Advice to decision maker on coal mining project

IESC 2020-111: Glendell Continued Operations Project (EPBC 2019/8409 and SSD 9349) – Expansion

Requesting agency	The Australian Government Department of the Environment and Energy (now the Australian Government Department of Agriculture, Water and the Environment) The New South Wales Department of Planning, Industry and Environment
Date of request	17 January 2020
Date request accepted	22 January 2020
Advice stage	Assessment

Figure 9: Yorks Creek Realignment Conceptual Design

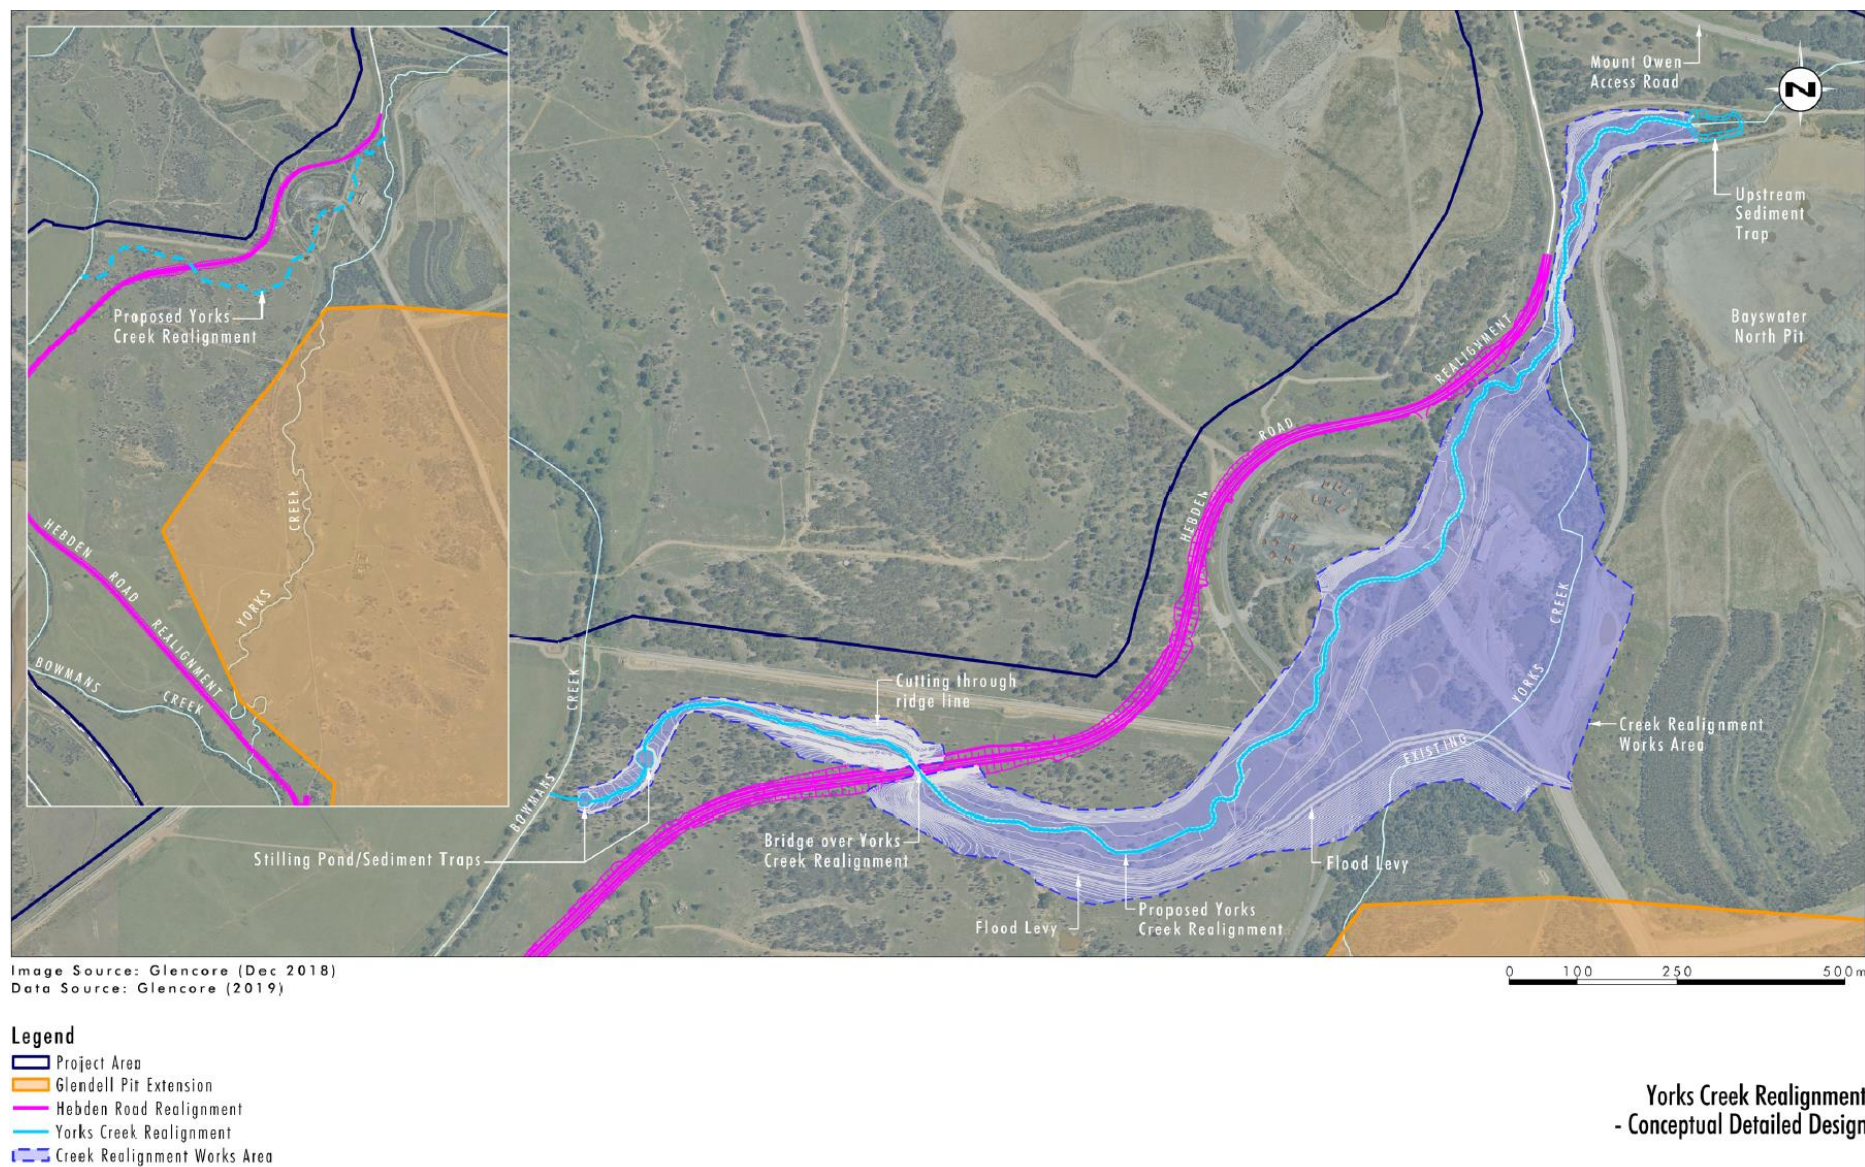
- Further modelling and detailed design work for the proposed Yorks Creek diversion is required to justify the proposed design and to assess whether suitable habitat, that is consistent with that in the lower reaches of creeks in the project region, can be reproduced within and alongside the diverted channel.

1% annual exceedance probability (AEP) event may exceed stability thresholds (GHD 2019, App. C, p. 29) although it is unclear where exactly within the Yorks Creek diversion this may occur. The proponent has stated that further detailed modelling is needed to identify appropriate mitigation measures. This modelling should be completed to inform the detailed design phase of the Yorks Creek diversion and development of the Rehabilitation Management Plan. If cross-sectional shear stresses are great enough to require rock armouring for channel stability, this will affect the habitat that can be produced in the diversion and potentially limit local riparian revegetation, disrupting its continuity along the diverted channel.

10. Additional discussion of predicted flood depths and velocities at the confluence of Bowmans Creek and the Yorks Creek diversion, and within the lower reaches of the Yorks Creek diversion (up to at least the Hebden Road crossing) should be provided. Current predictions show that the lateral extent of flooding within Bowmans Creek at the confluence is less than in many other parts of Bowmans Creek and that ponding in the lower reaches of Yorks Creek diversion is not expected. Given the significant change in bed slope from 0.04 m/m to relatively flat conditions that occurs 150 m before the confluence (Gippel 2019, p. 37), further assessment of the stability of the watercourse (see Paragraph 36) is required.

Figure 16: Conceptual Final Landform

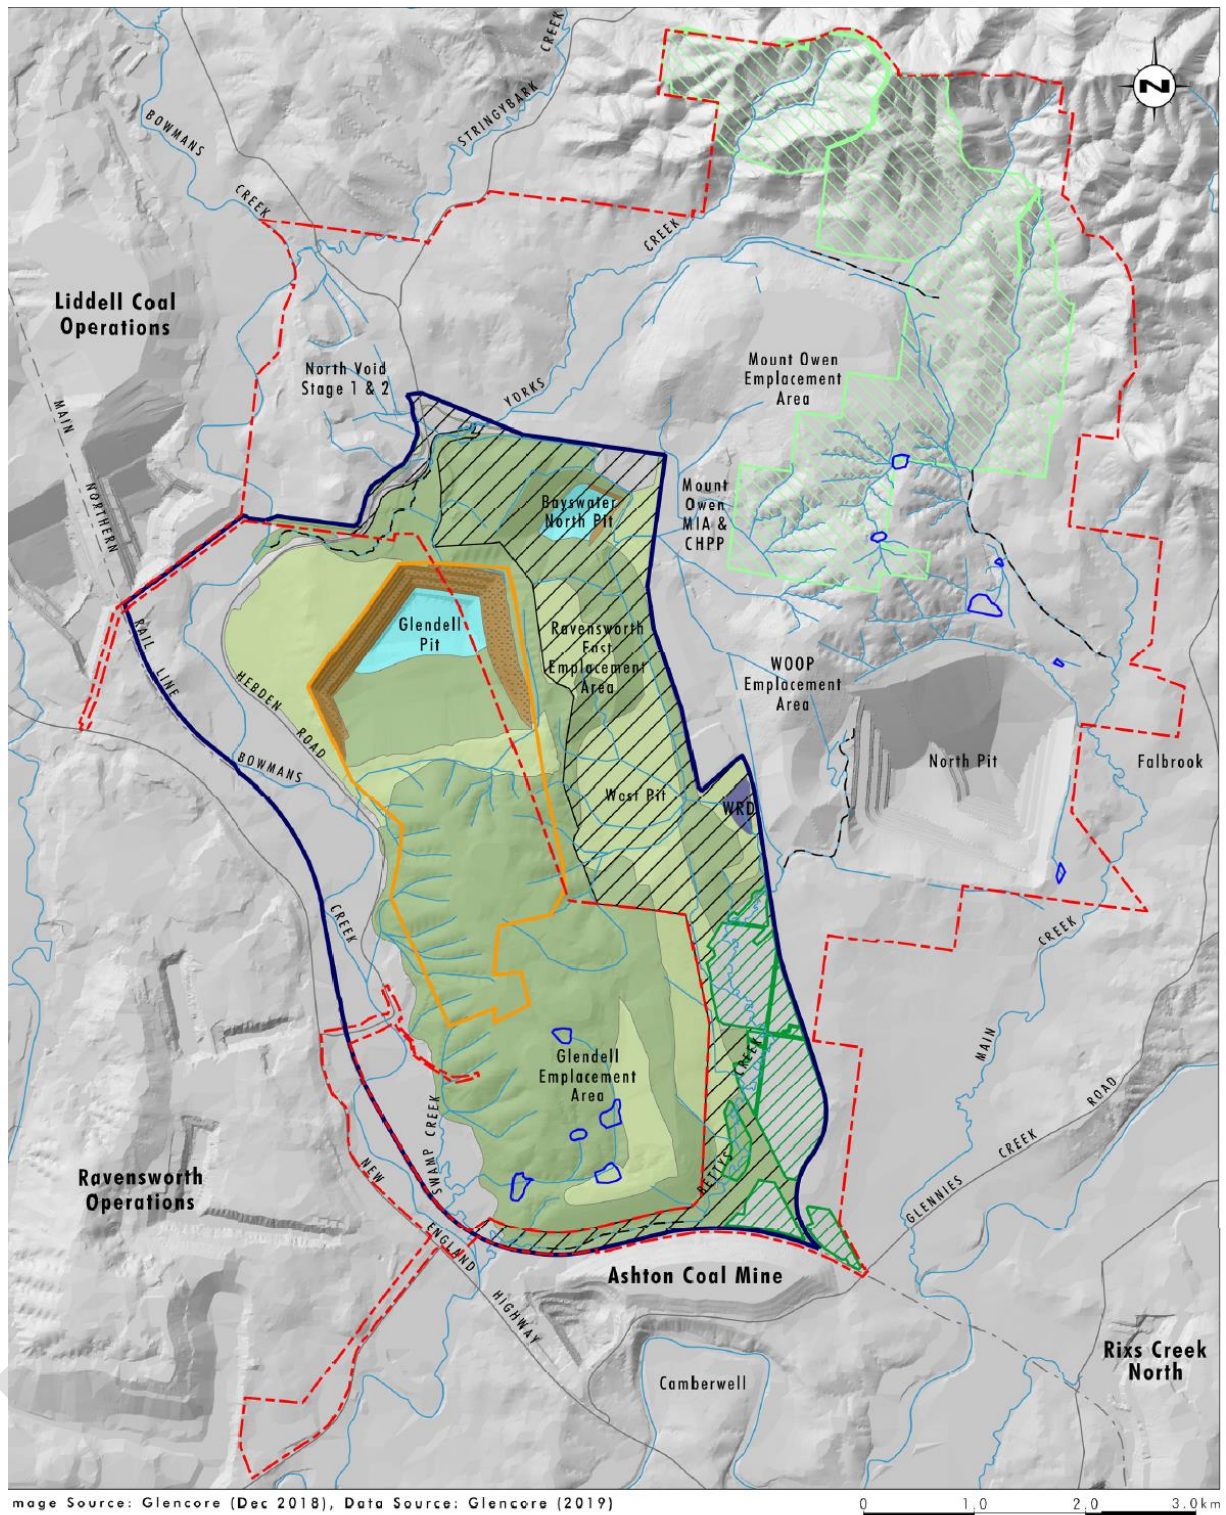
General

Question 1: Do the groundwater and surface water assessments in the EIS provide adequate mapping and delineation of surface and groundwater resources?

1. The Environmental Impact Statement (EIS) generally provides adequate mapping and delineation of surface water and groundwater resources at a broad scale.
2. Modelling of a 'unit' pool to predict potential impacts on refugial pools has limited value given each refugial pool will have unique characteristics that cannot be captured by modelling of a single 'representative' pool. The IESC instead suggests the proponent undertake further field studies to map refugial pools and determine their characteristics including groundwater connectivity. This information should be obtained for all refugial pools in potentially affected creeks, particularly those within Yorks Creek that will likely be lost and which should, ideally, be recreated within the diversion.
